Wilton Mills 586 Bradford Road, Batley, WF17 8LP

Demolition of existing garage and erection of MOT bay/service bay/storage area (within a conservation area)

We strongly oppose the above planning application.

PROPOSED SITE (BLOCK) PLAN  
SCALE - 1:200

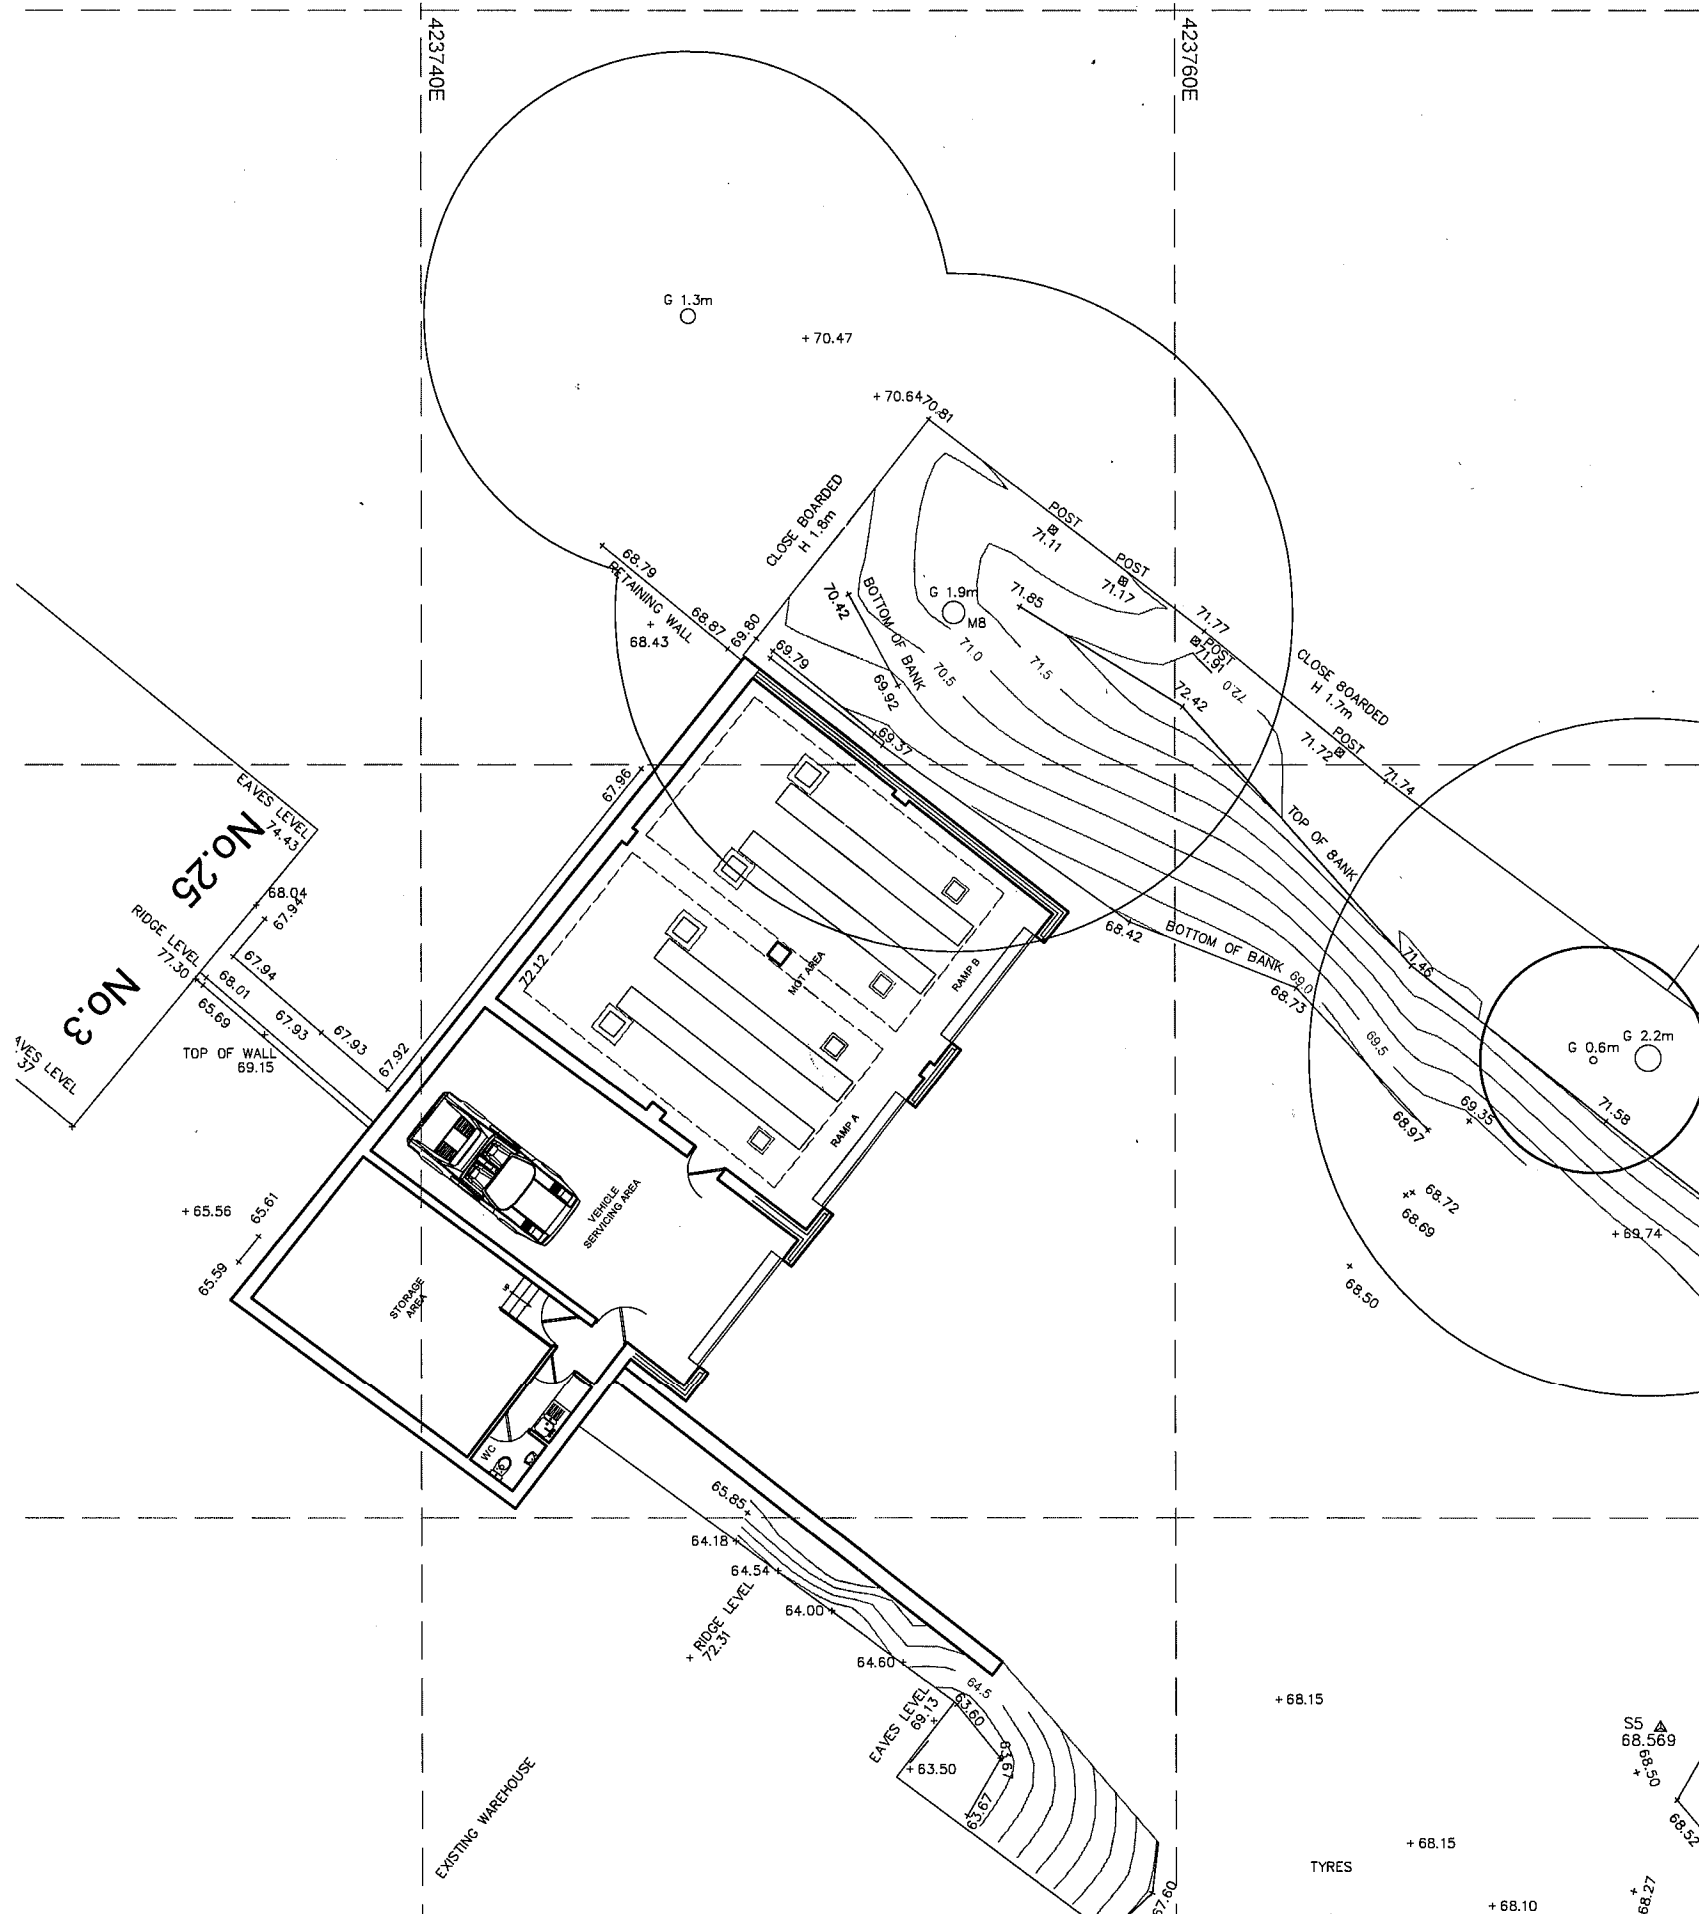
The current proposal aims to make the garage larger and to be used for a HGV mot station. To demolish and rebuild a larger bigger building with greater height that is above the existing roof line. This will have a negative impact on the natural light available to the row of terrace houses at the bottom of Carlinghow Hill.

As with regards to the land being in a dilapidated state this has been caused by individuals using the land for purposes that are not stipulated in the planning, and not enforced by Kirklees. It should be a tarmacked area with marked bays for parking of which 10 % should be for disabled parking.
